TO:	Arun District Council FAO: Mr S David
FROM:	Highways, WSCC
DATE:	20/07/2018
LOCATION:	Sack Lane Dairy, Sack Lane, Bognor Regis, PO22 9PD
SUBJECT:	AL/60/18/DOC Application for approval of details reserved by conditions imposed under planning permission AL/58/17/PL relating to condition No. 4 (Surface water drainage scheme), 5 (Contamination), 6 (Hard and Soft landscaping), 7 (materials), 8 (details of new screen walls and fences), 11 (Secure & covered bicycle stores), 12 (details of storage of waste and recycling) & 17 (external lighting).
DATE OF SITE VISIT:	n/a
RECOMMENDATION:	Advice
S106 CONTRIBUTION TOTAL:	n/a

Condition 4 (Surface water drainage scheme)

Drawing Number: 2015/15/25 Rev.

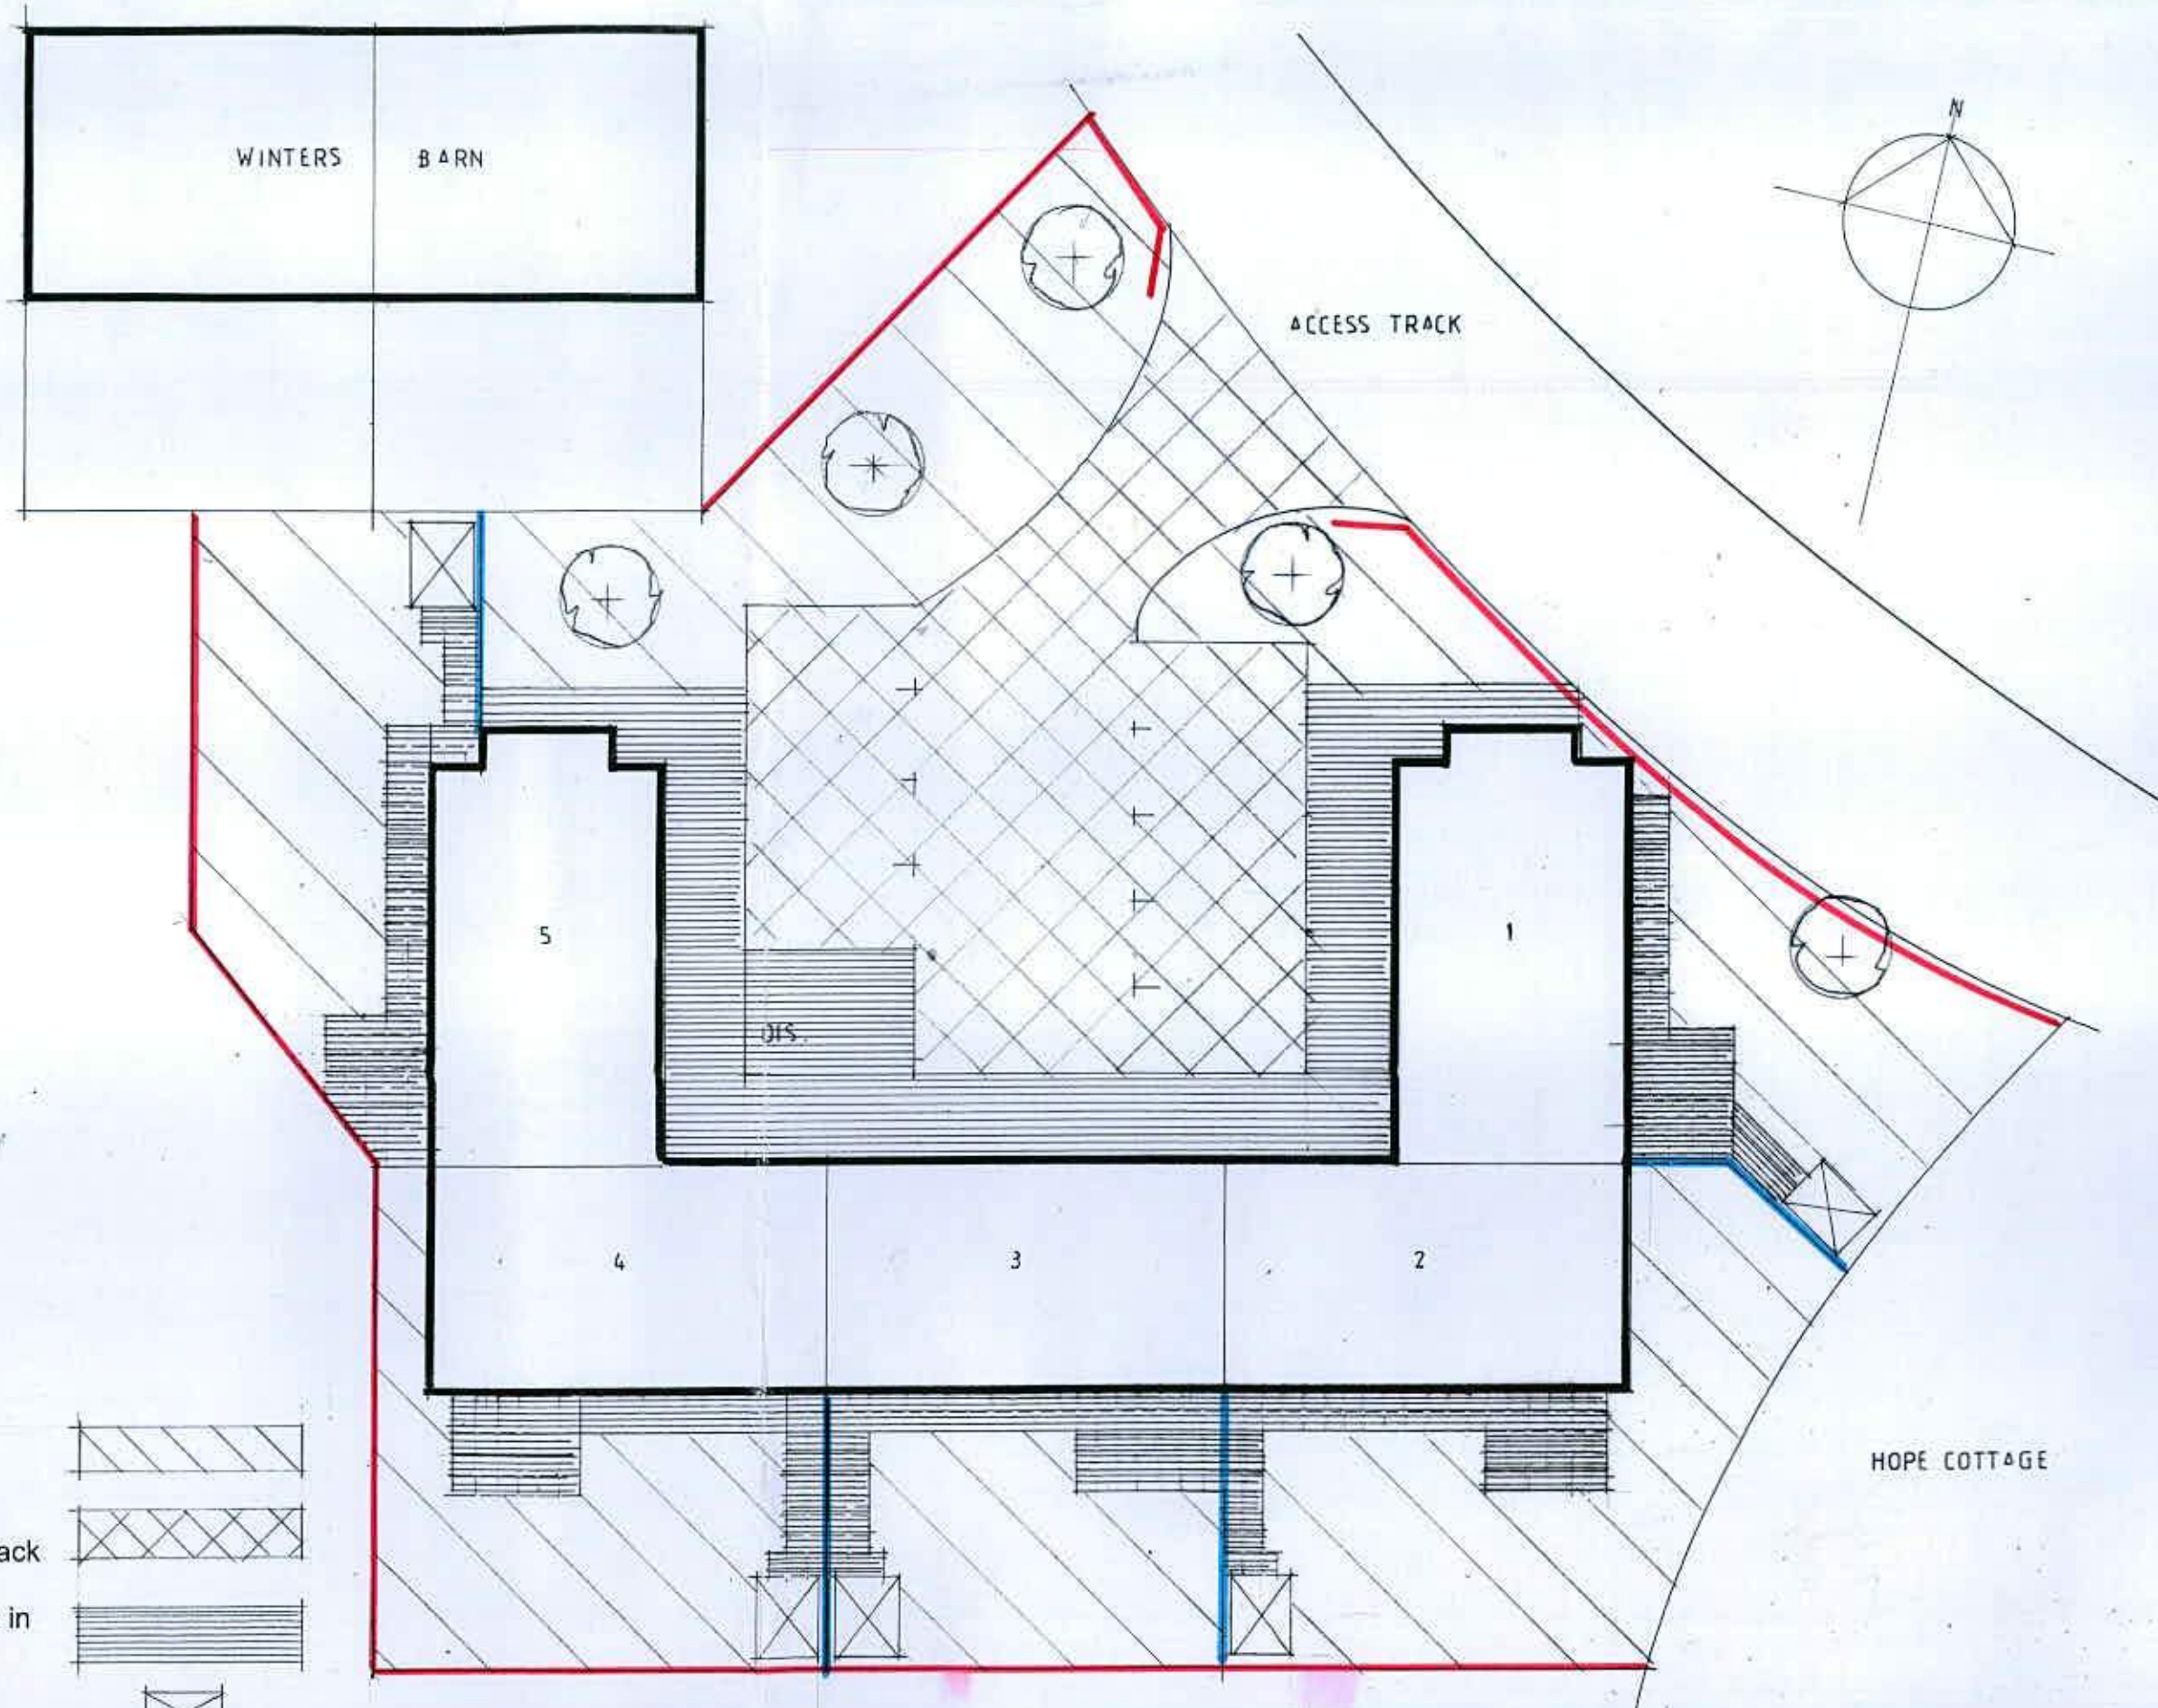
Plan 2015/15/25 indicated each dwelling will be provided 2.4 x 1.8 garden sheds to be used as cycle stores. These would be considered appropriate to fulfil the requirements of this condition.
